From: Sue Howell
Sent: 11 December 2017 16:03
To: Michael Eastham
Subject: RE: LU/121/17/RES - Toddington Nursery site

Re LU/121/17/RES

We therefore confirm that we would recommend that we have no objections on Landscape grounds to the proposals submitted under reserved matters application LU/121/17/RES following consent LU/47/11.

A088461 LA100-108 Rev J.dwg 7 Dec 2017

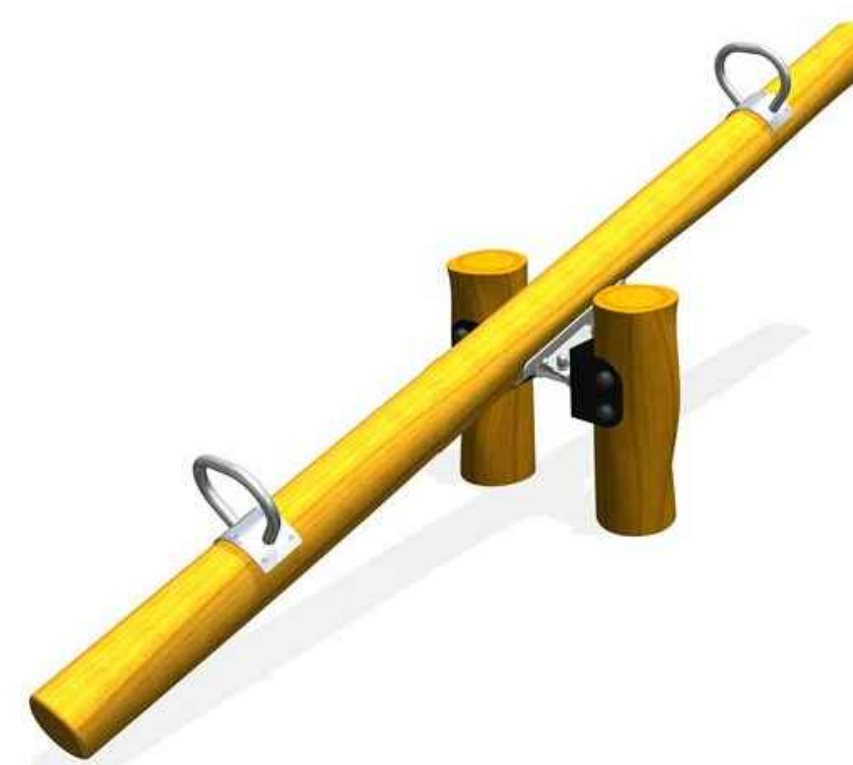
The LEAP Play proposals LA106 contained within drawing A0088461 LA100-107.dwg, does provide a good play experience with a variety of play experiences being provided for this younger age range. This has now also detailed fencing and gated play area detail.

General tree pit detail
Scale 1:10

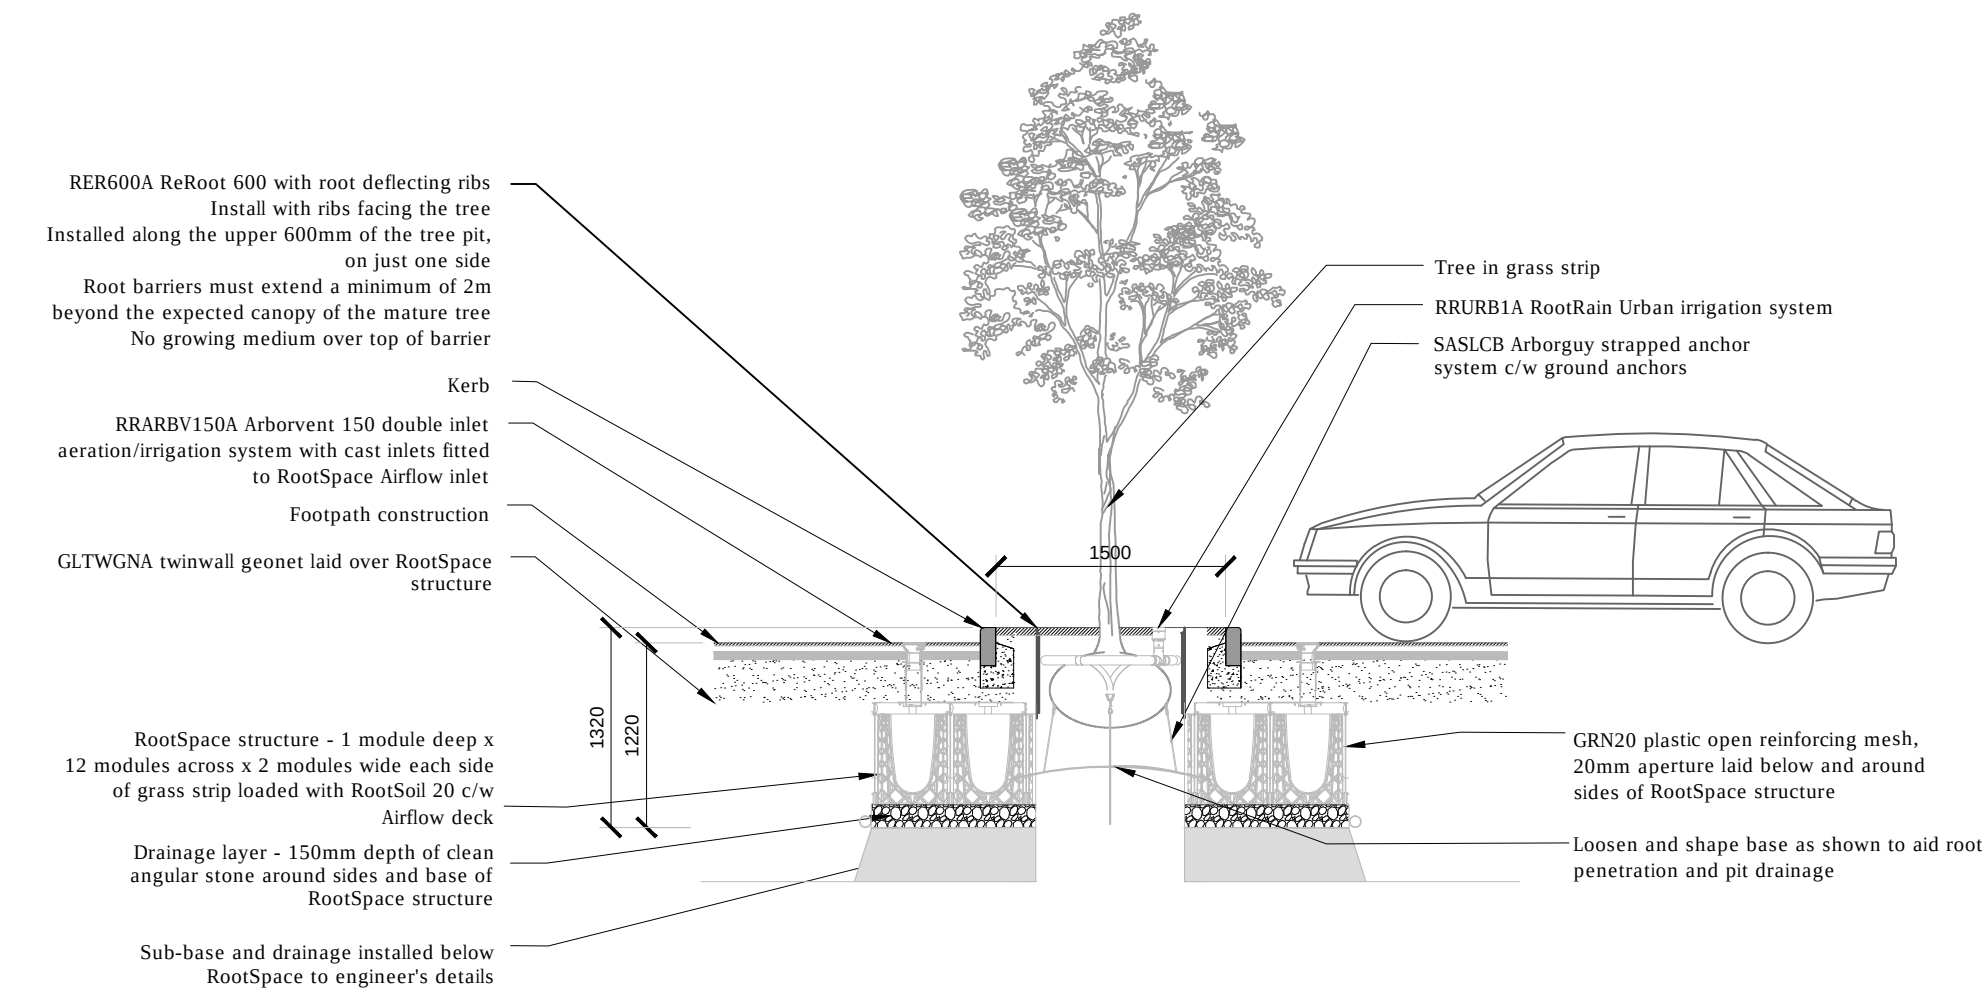
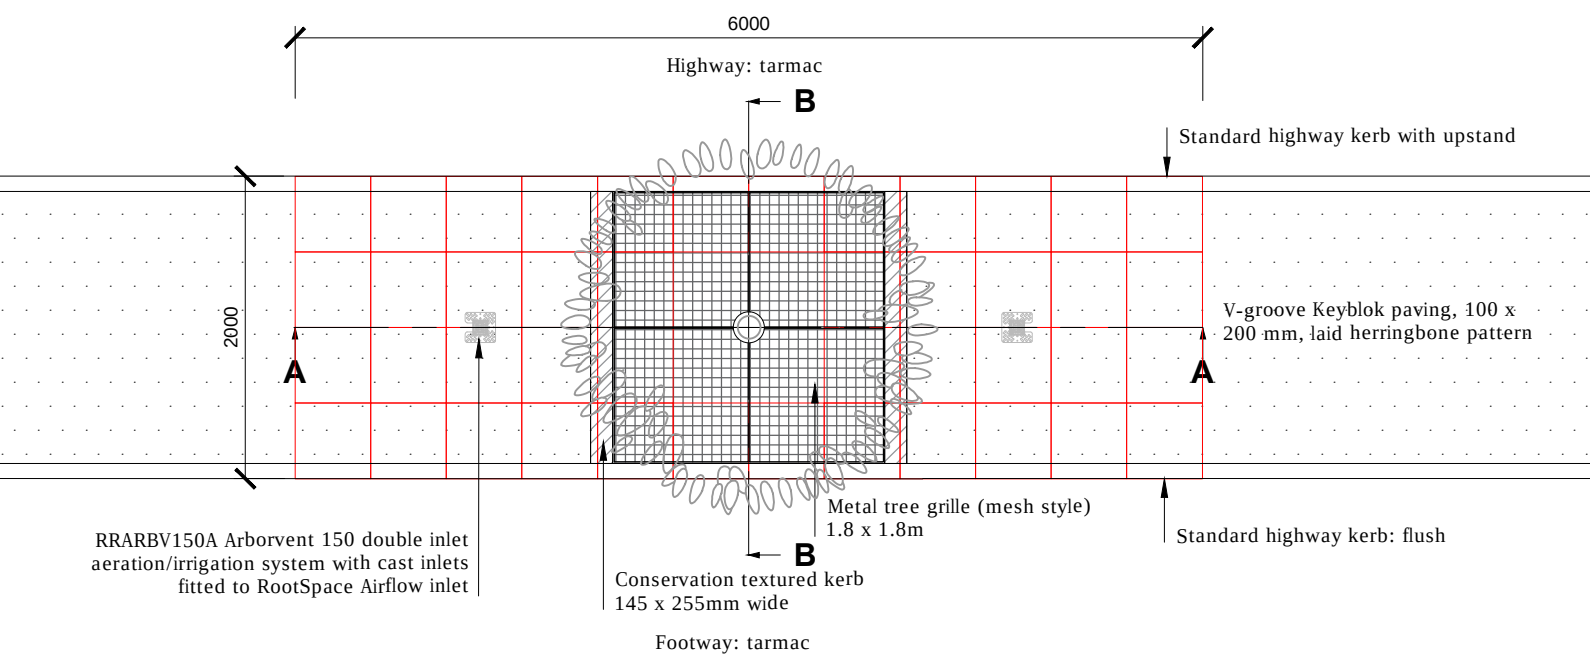
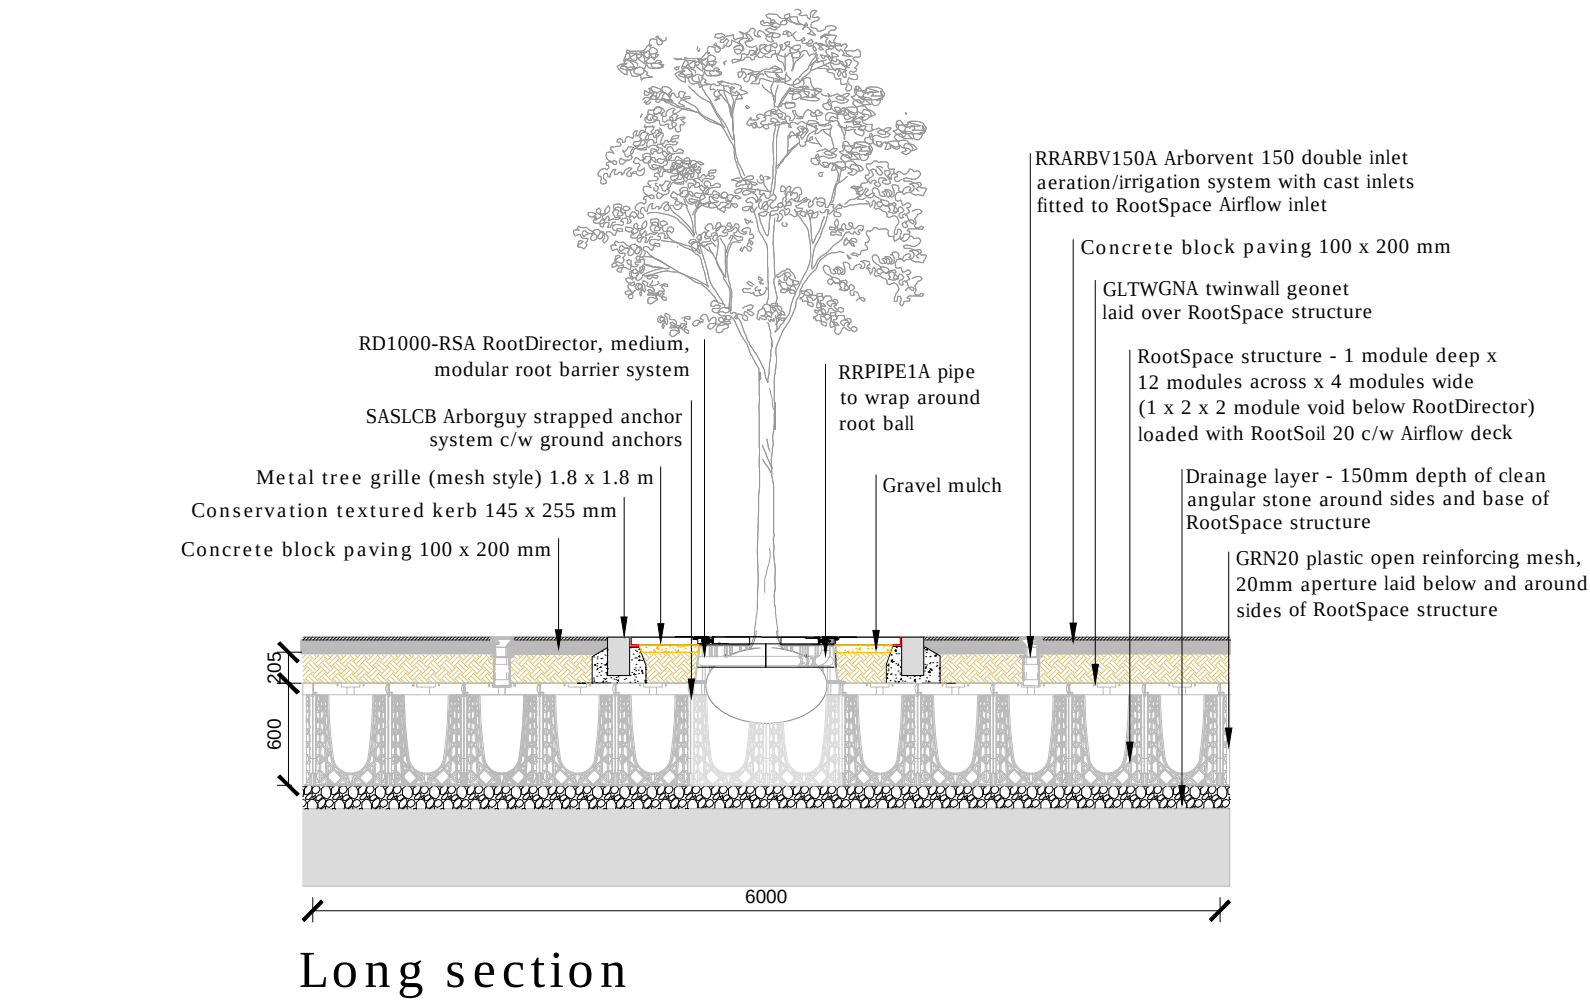
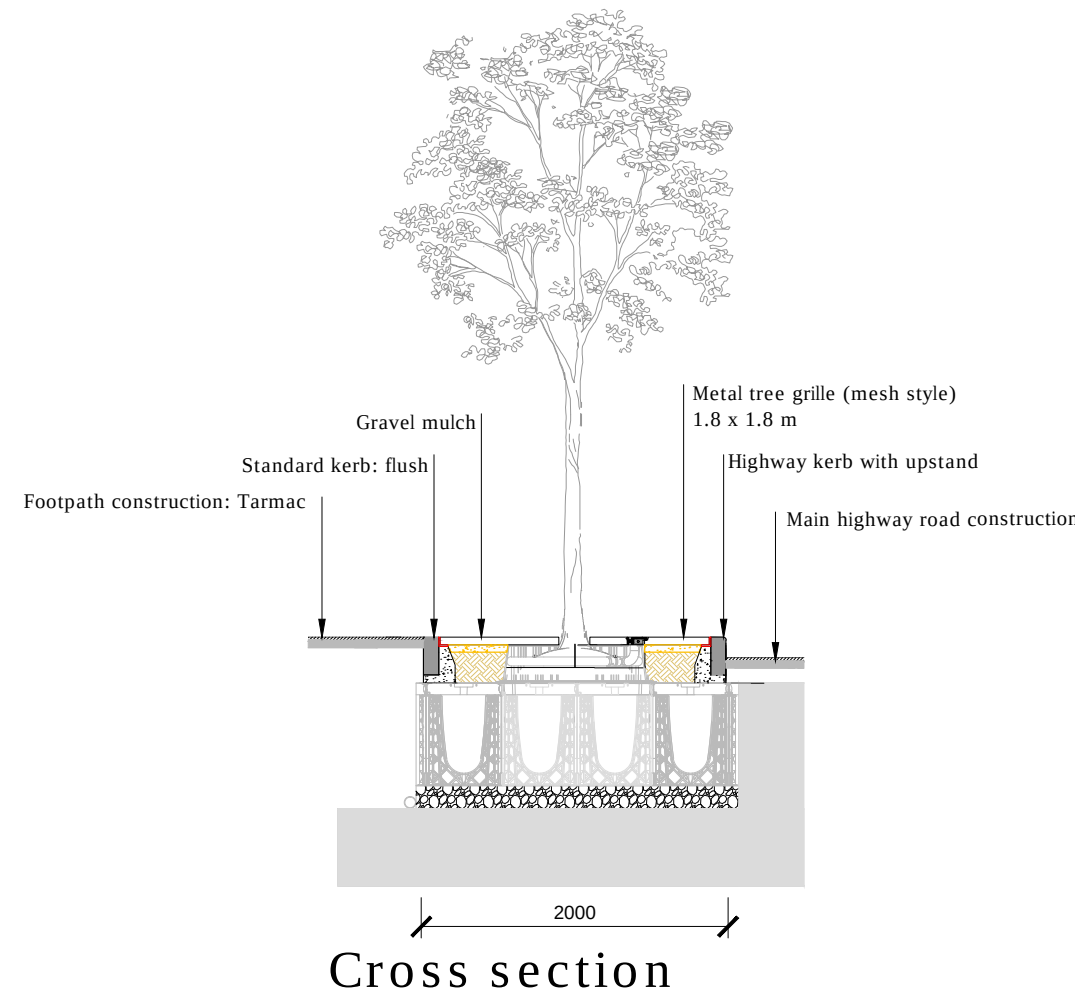
The submission of planting pit formation cross section and specification is good to see and this has shown detail regarding the inclusion of watering tubes and 'deadmen' underground guying systems. The detail for the trees to Main Avenue includes a root support system which includes growing medium specification, root directors/barriers, aeration system, irrigation and anchors. This attention to detail along with adequate follow up maintenance and watering to establishment should support long term thriving growth and establishment.
